From: Amanda Scholes on behalf of Planning.Responses
Sent: 17 October 2019 08:51
To: Planning Scanning
Subject: FW: Confirmation of info

From: Nick Hopper [REDACTED]
Sent: 16 October 2019 15:54
To: Richard Castro-Parker [REDACTED] <k>
Subject: Re: FW: Amended plans re: 71 Hawthorn Road

The current amended plans do not confirm that the ground floor flat is to be 1 x 2b 3p, the first floor flat a 1 x 1b 1p and the second floor flat is to be 1 x 1b 1p. Please can you confirm this to be the case. The internal space standards have been applied based on the flats being as aforementioned.

Drg.No. ADS-005-P A

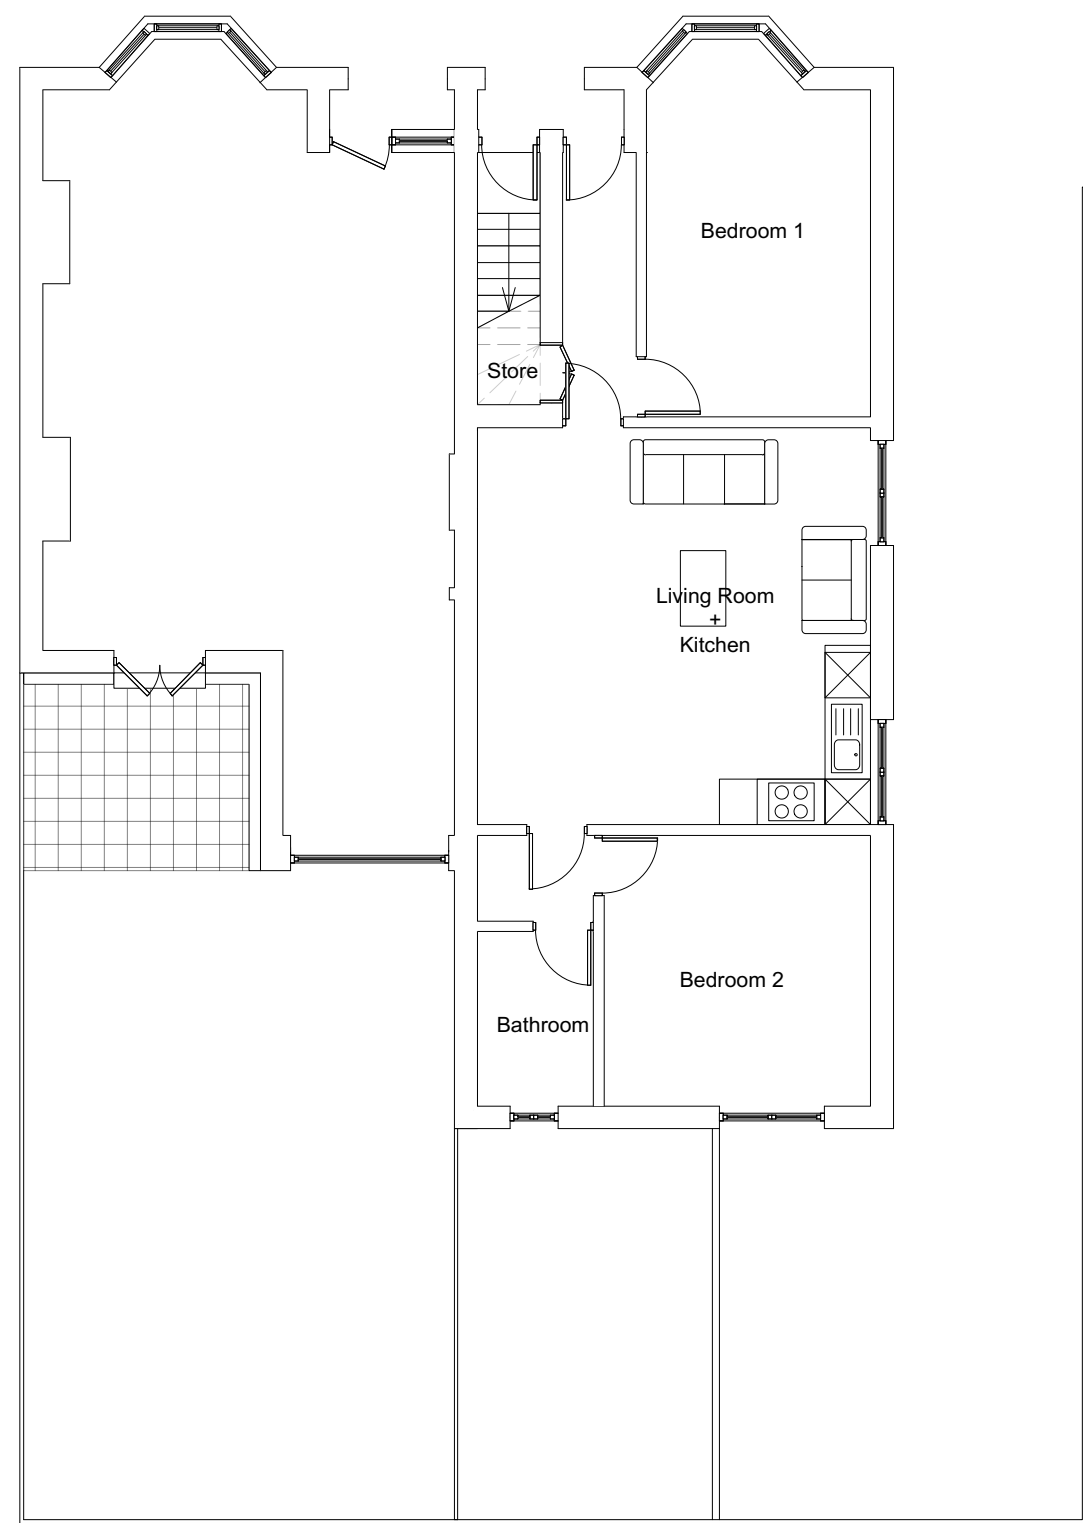
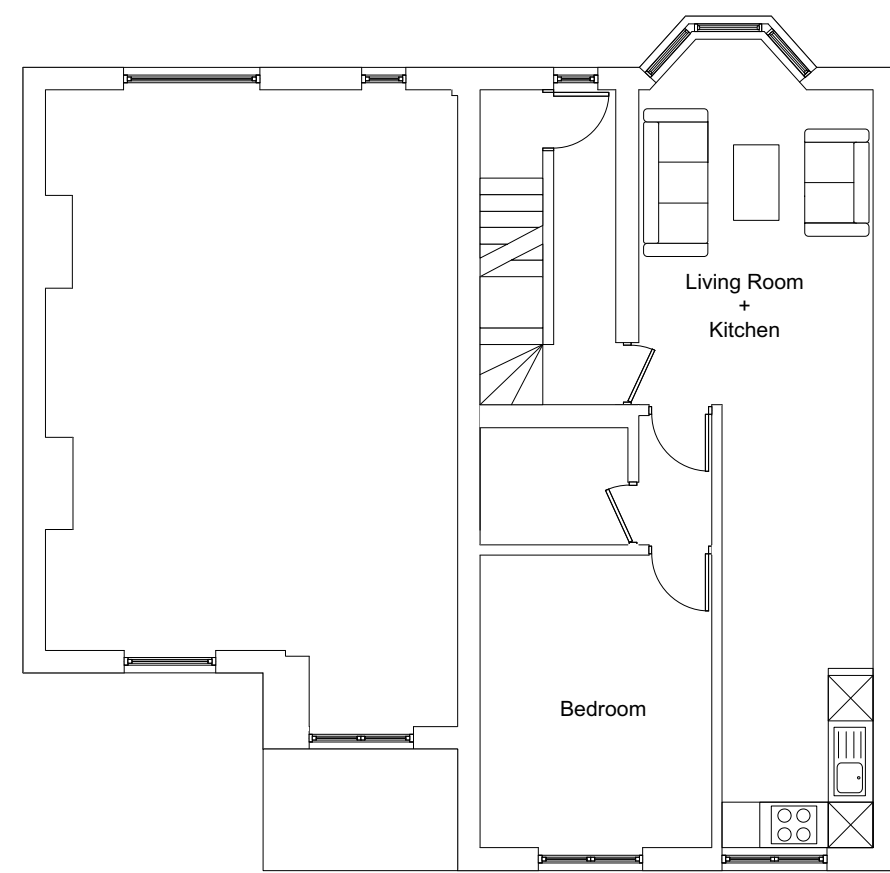
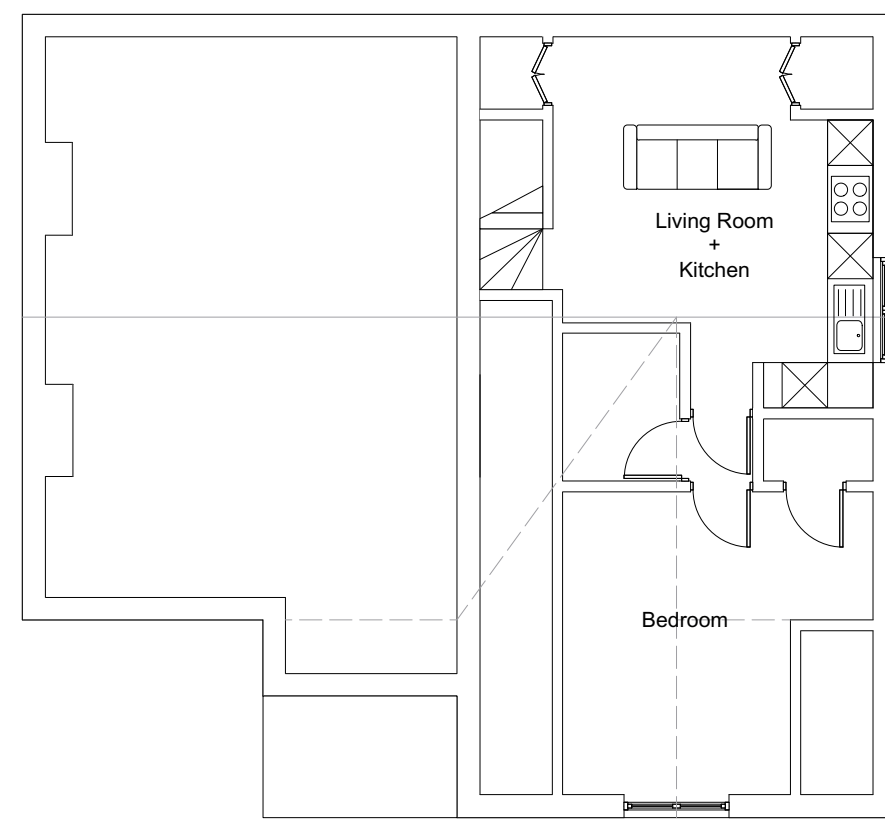
It has just come to my attention that the amended plan as submitted does not include the floor plans and internal space standards plans. The floor plans are currently shown on plans that are not being approved due to the old parking scheme being shown.

Yes, that is correct.
Thanks
Nick
